Rezoning Transportation Analysis

Petition Number: 2022-147

From: Jake Carpenter, PE

Date	Description
1-25-23	First Review (IW)

RZ-101

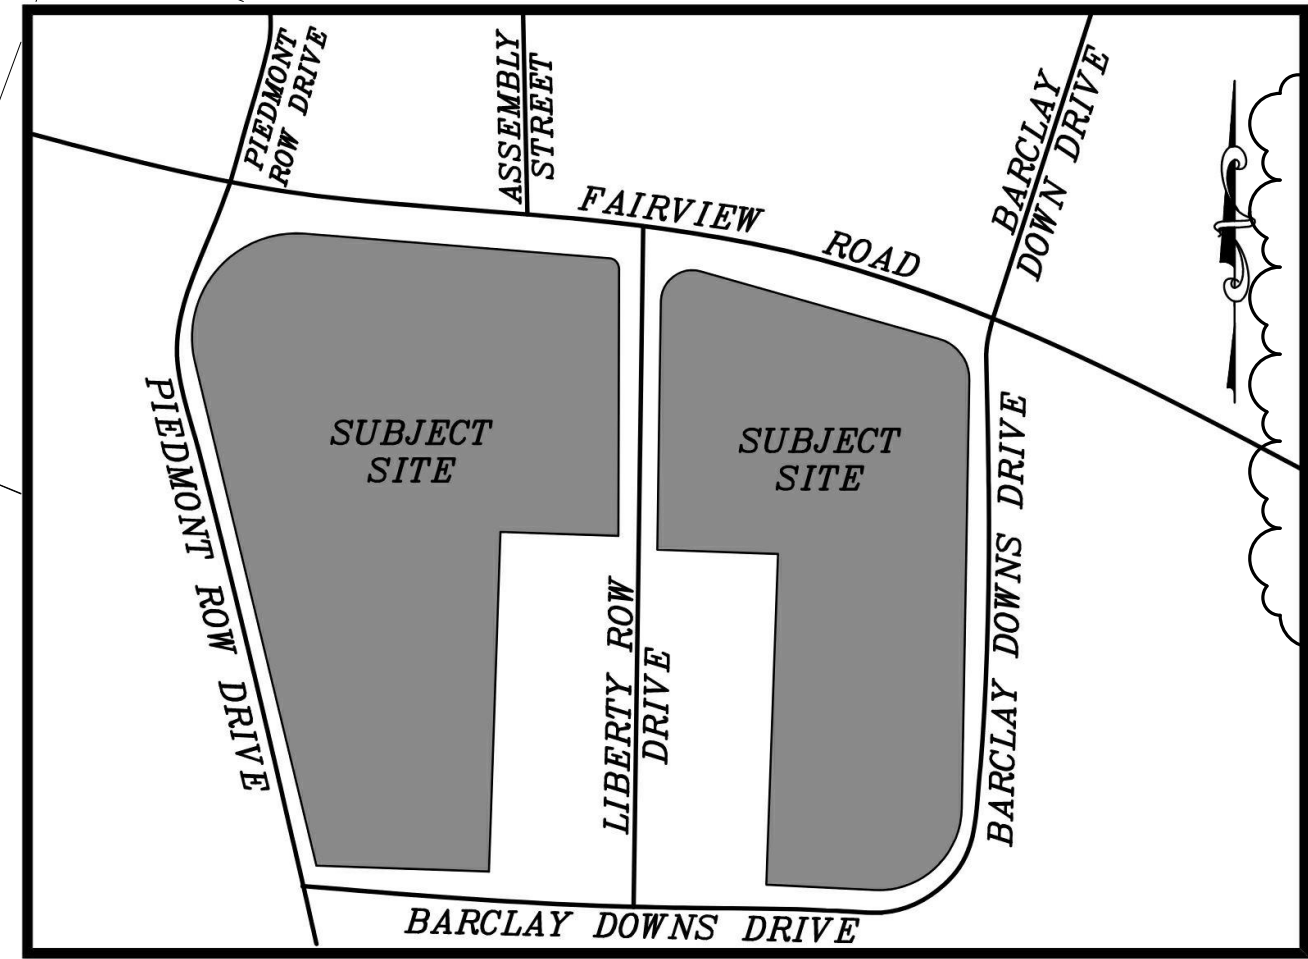
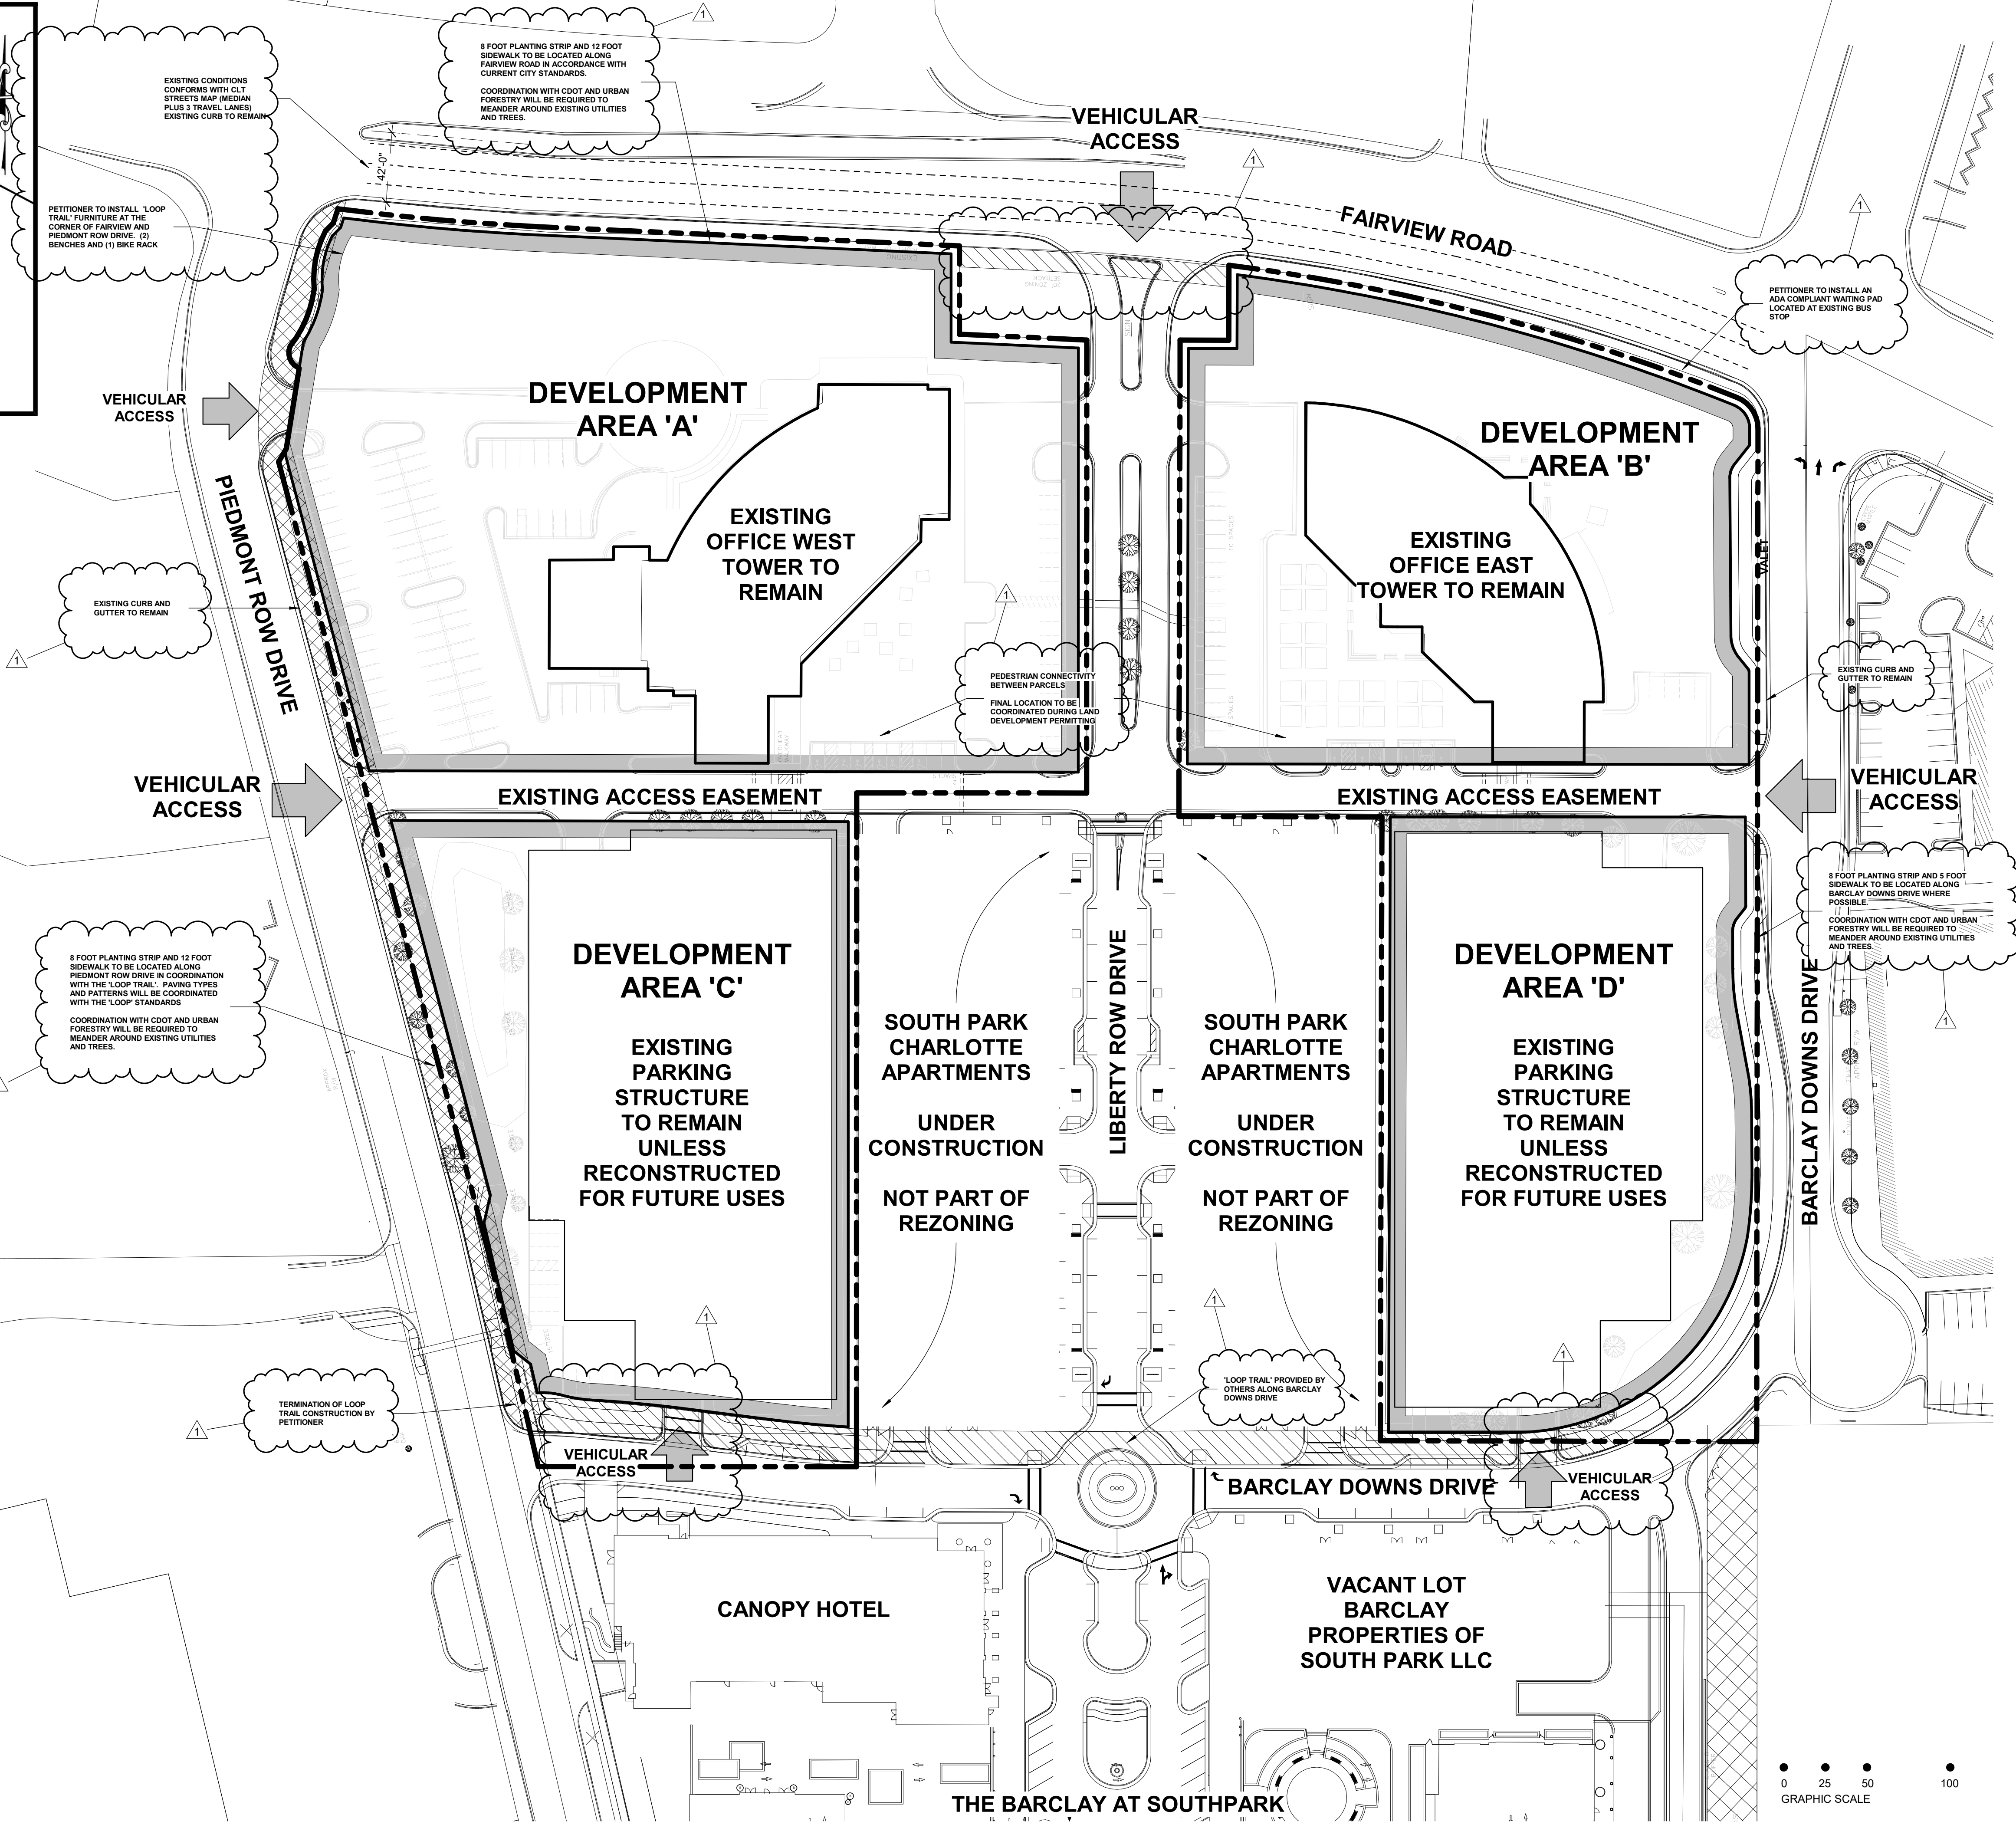
- Fairview Road:** Location of future curb and gutter to be 41 feet from roadway centerline to accommodate the Charlotte Streets Map with a roadway typical section of CLDSM 11.09 Major Thoroughfare.
- Piedmont Row Drive:** The future location of curb and gutter is in its existing location.
- Barclay Downs Drive:** The future location of curb and gutter is in its existing location.

Label and dimension the curb and gutter from the centerline for each road on the site plan.

- Revise site plan and conditional note(s) to commit to dedicate 63 feet of right-of-way from the Fairview Road centerline. The site plan shall label and dimension the right-of-way from the road centerline.

4. Revise site plan and conditional note(s) to commit to constructing The LOOP standard 12 foot sidewalk along the portion of the property frontage where The LOOP is designated to be constructed. As shown below, The LOOP path is along the southern portion of Barclay, goes North on Piedmont Row Drive, and crosses Fairview at the existing crosswalk.

5. Revise site plan and conditional note(s) to commit to construct an 8-foot planting strip, and 12-foot Multi-Use Path on Fairview Road to support the City Council adopted Charlotte Streets map, and to meet the Council-adopted Charlotte BIKES Policy. Multi-use paths maintained by the City shall meet ADA/PROWAG requirements. The site plan shall label and dimension both items from the back of curb and gutter or edge of pavement.
6. CDOT is requesting that the petitioner revise site plan and conditional note(s) to commit to construct an 8-foot planting strip, and 5-foot/ sidewalk along the Eastern portion of property along Barclay Downs Drive. The site plan shall label and dimension both items from the back of curb and gutter or edge of pavement.

8. Per coordination and request of The LOOP project team: revise site plan and conditional note(s) to commit to install LOOP branded furniture within property boundary that includes 2 benches and a bike rack near intersection of Piedmont and Fairview within Development Area "A". The LOOP project team has already purchased the furniture, the request is for the developer to install it.
